Our reference: P-592792-M6T6
Contact: Sandra Fagan
Telephone: (02) 4732 7992

12 December 2023

**Council Response to Environmental Impact Statement – SSD-58257960
– Aspect Industrial Estate Stage 3 Warehouse 2 at 804-882 Mamre
Road, Kemps Creek, NSW, 2178**

Figure 1: Site Plan

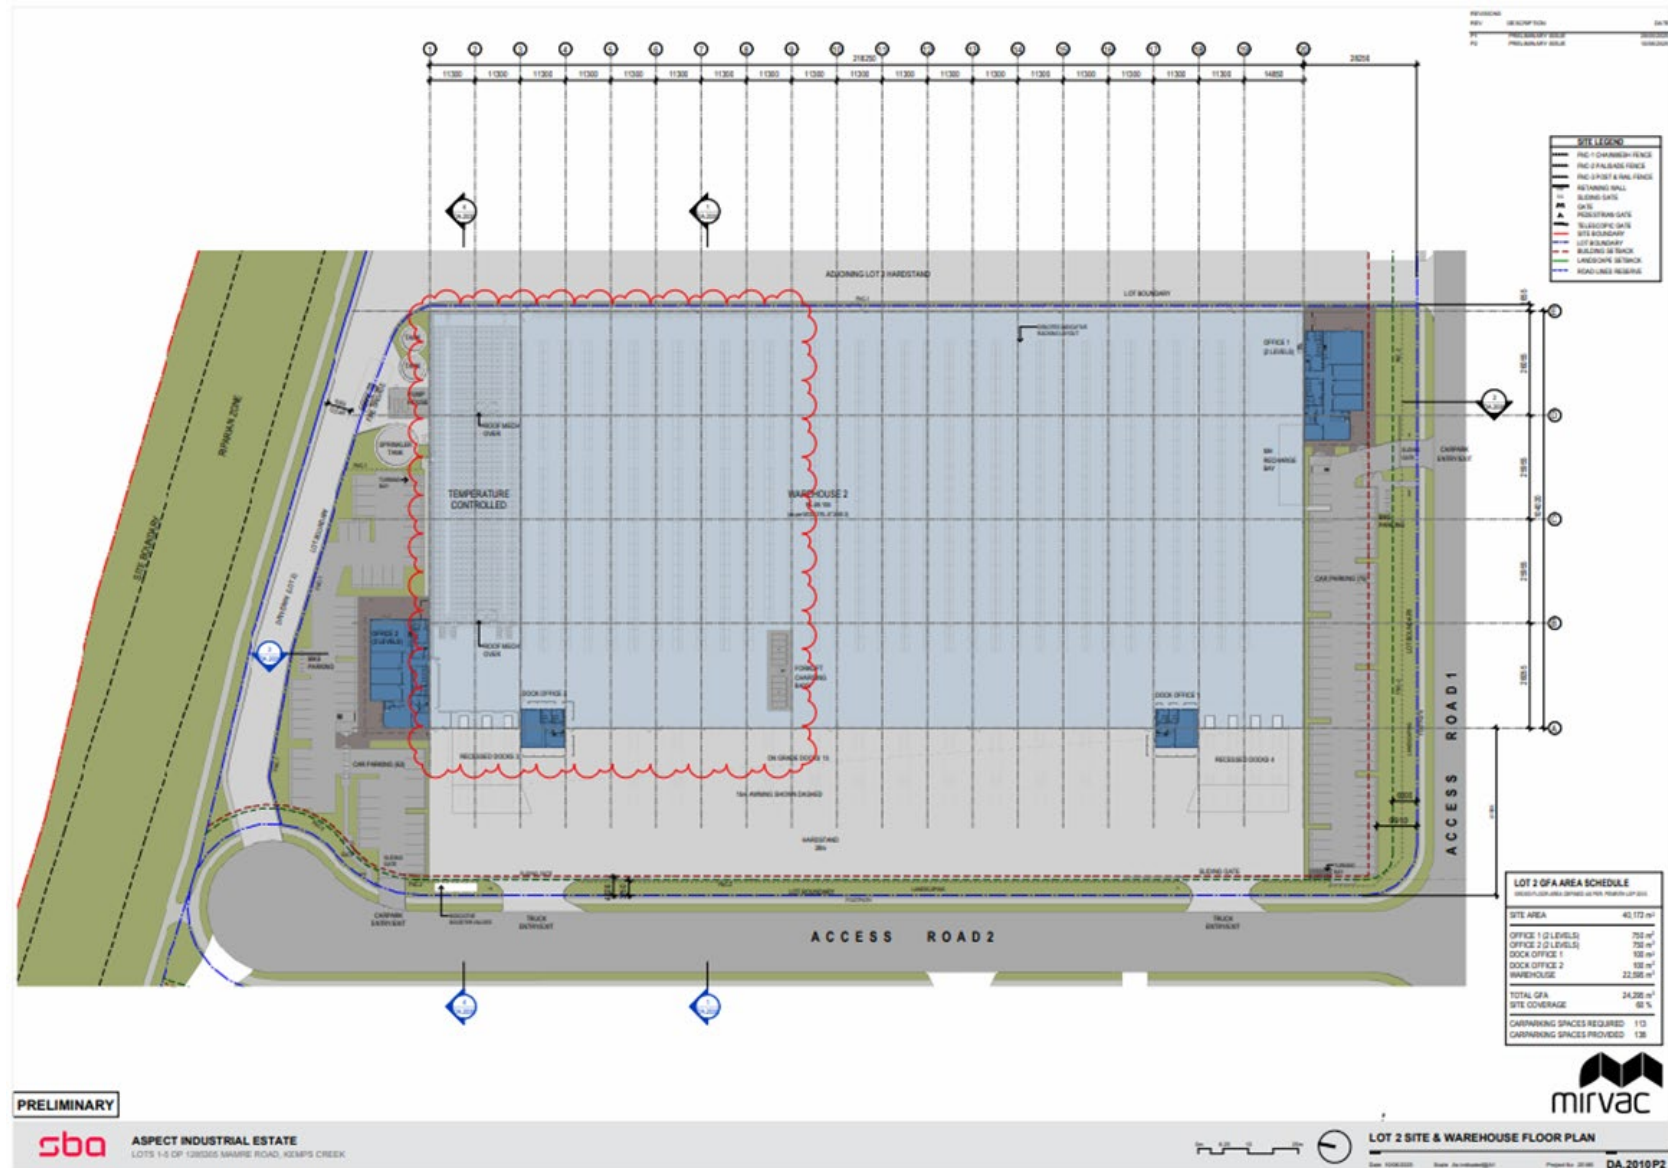
- f) Proposed signs S2 and S3, at the truck and car parking entries located at the north-west corner, (shown on architectural drawing DA290A) are positioned very close to each other. It is acknowledged that both signs relate to their respective vehicular entry, however, their proximity may lead to visual clutter and impact on landscaping in that area. The S2 sign will be 2.1m high and the S3 sign will be 3.3m high. Both signs relate to wayfinding for tenants and car parking. DPE should consider whether the two signs in this location can be collated into one sign and/or repositioned to ensure a better physical and visual separation.

- g) Further, the Landscape Plans show five new trees to be planted between the car and truck driveways referenced above. This would appear to conflict with the proposed position of signs S2 and S3. Given the already narrow landscaped setback in this location, landscaping is preferred over signage. The way-finding signage should either be reduced in size and number, and/or repositioned.

- a) There is no waste management plan provided and the architectural plans do not indicate any waste storage area within the built form of the proposed development. DPE should be satisfied that the proposal includes adequate details and methods for handling waste generated by the proposed use.
